Norfolk Vanguard Offshore Wind Farm

Consultation Report

Appendix 22.1 Section 42 Responses

Date: June 2018
Revision: Version 1
Author: BECG

Drawing file: published-documents / EN010079-001679-Figure 8.11 Regional Sediment Transport Pathways in the Vicinity of Norfolk Vanguard (Kenyon and Cooper, 2005).pdf

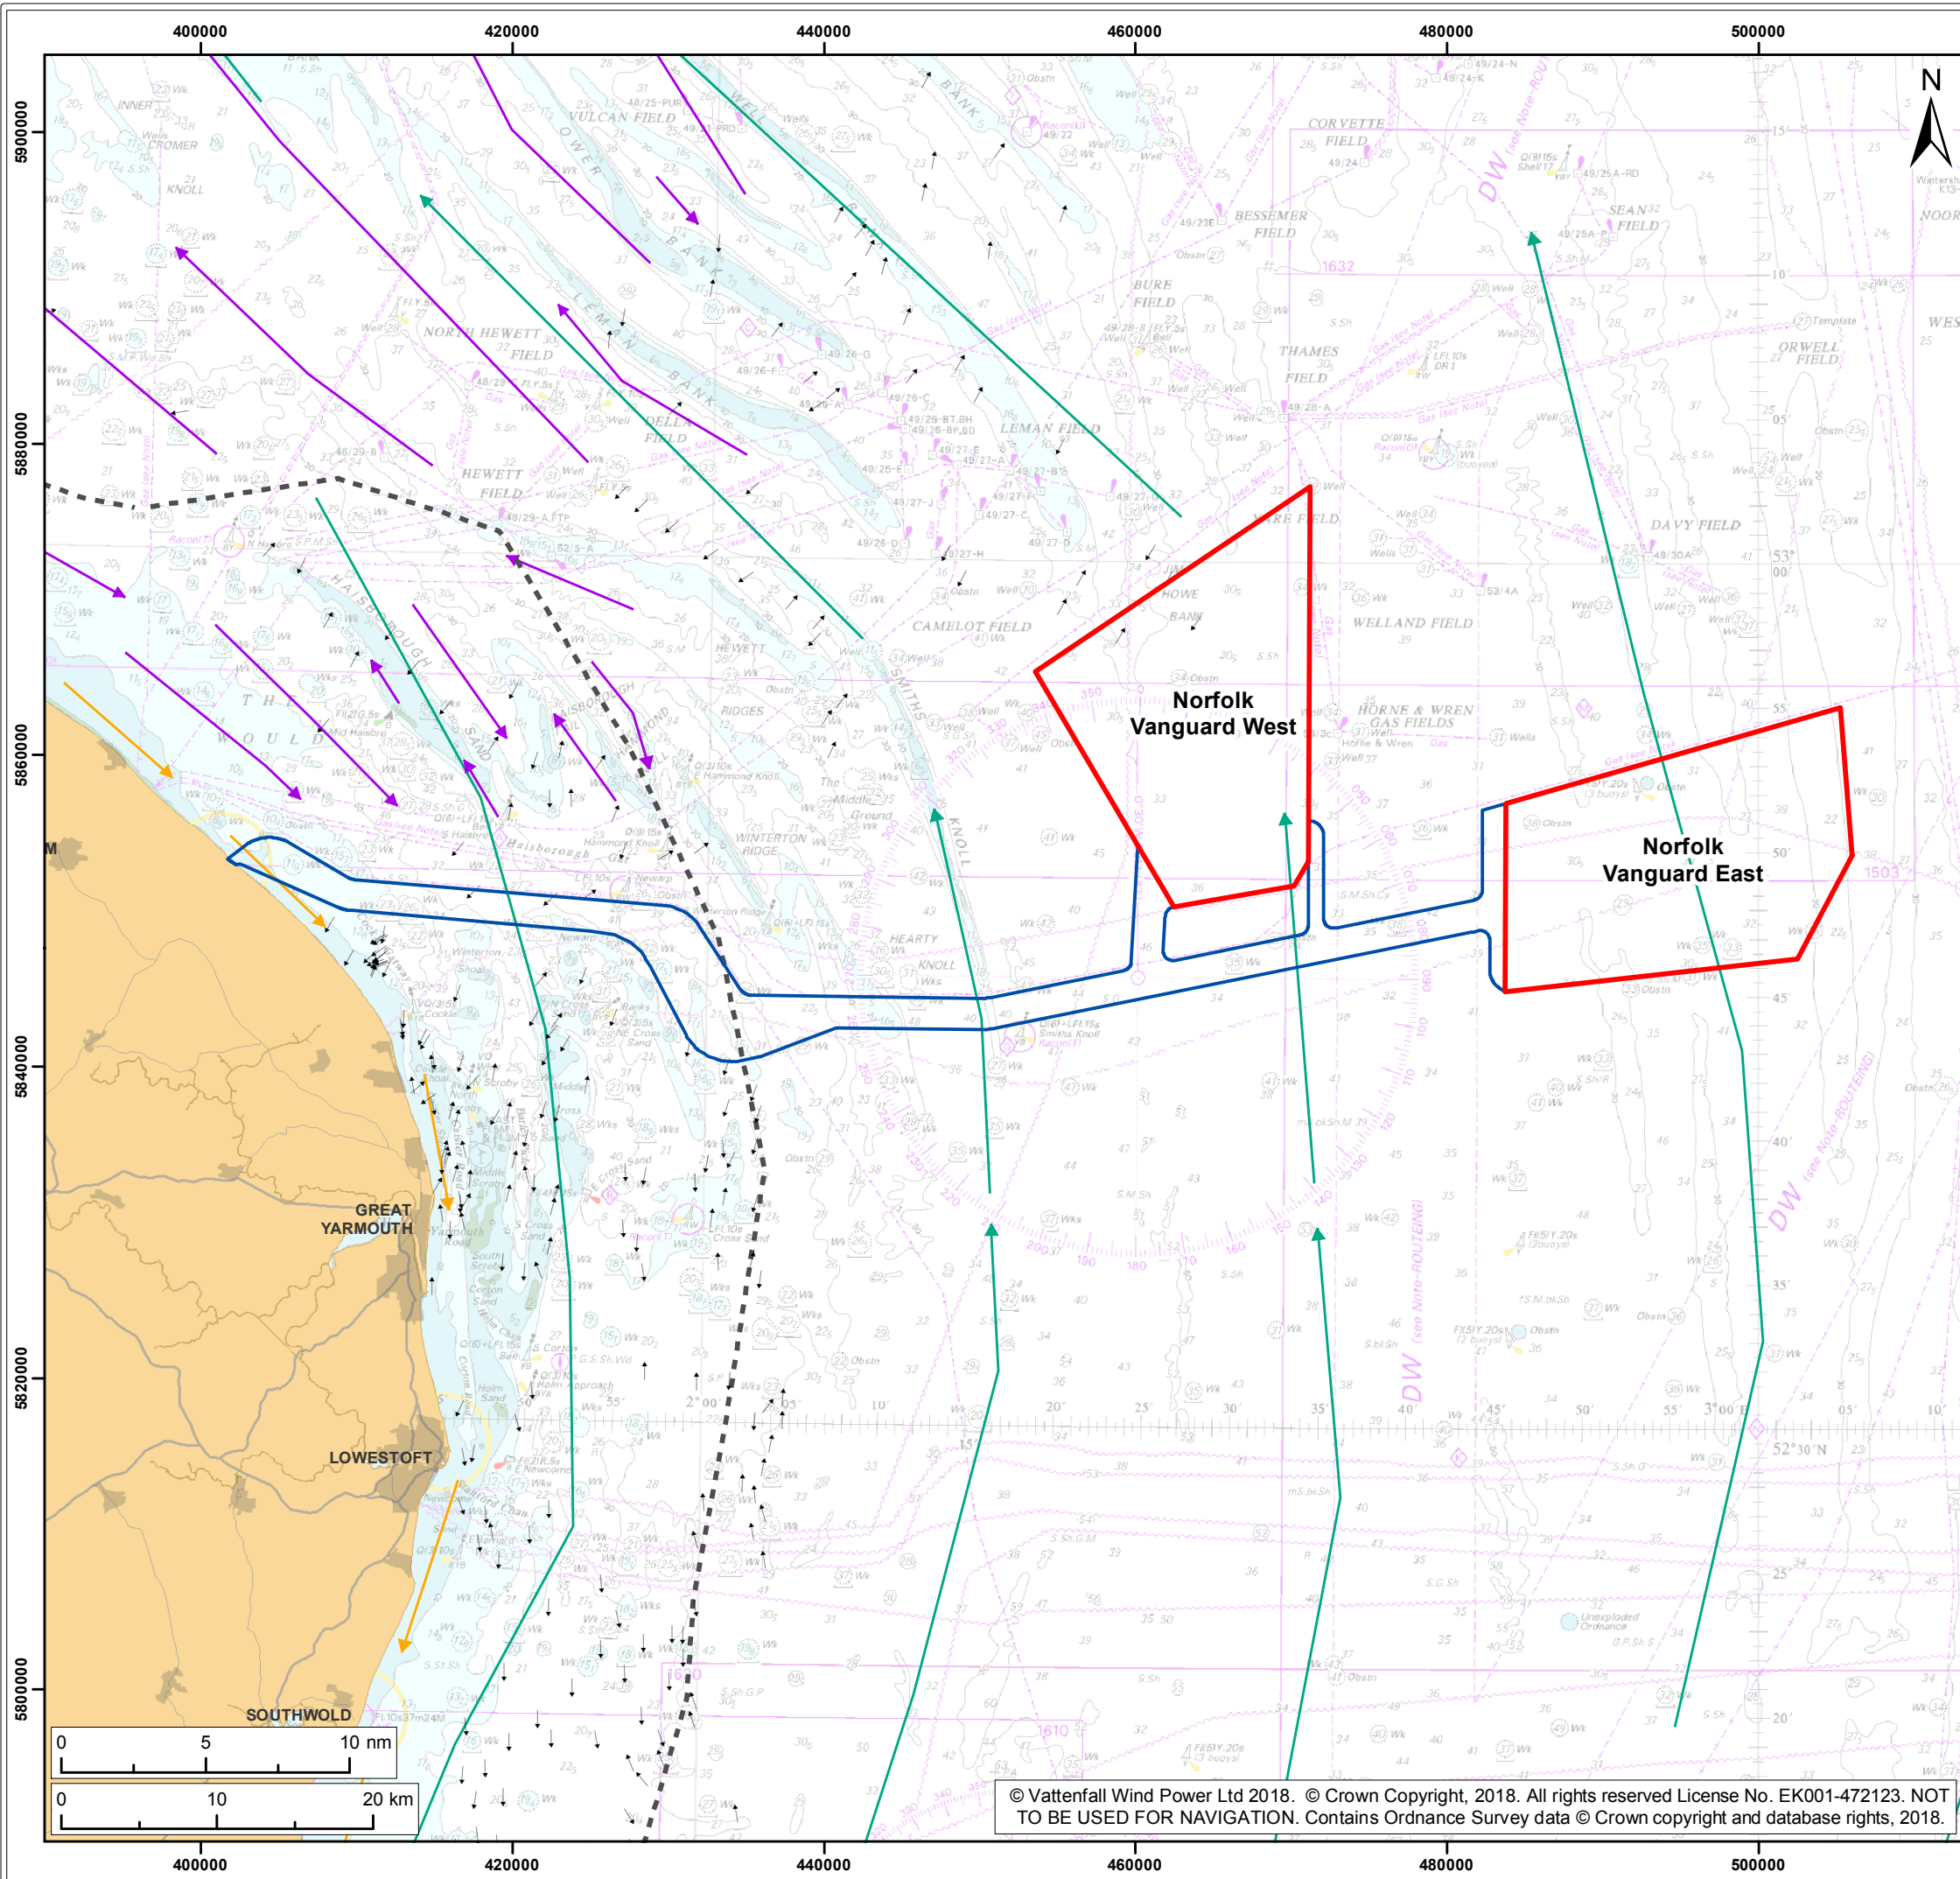
Chapter 8 Marine Geology, Oceanography and Physical Processes	Cefas	Written feedback dated 1 st July 2017 (provided 6 th July 2017) in response to an early draft of the PEIR chapter dated 21 st June 2017	A regional sediment transport map should be provided (to accompany sections 8.6.8 and 8.6.9). Not only would this be useful in respect of statements made later in the report (e.g., that there is no pathway for changes offshore to affect the shoreline), but it would be a major piece of evidence in support of the assumption that the physical contexts of the East Anglia OWF are sufficiently similar to Norfolk Vanguard to justify their use as primary evidence for impact assessment of the latter. It would also clarify the step to section 8.6.11 (coastal process at the	Figure and explanation added to section 8.6.8.
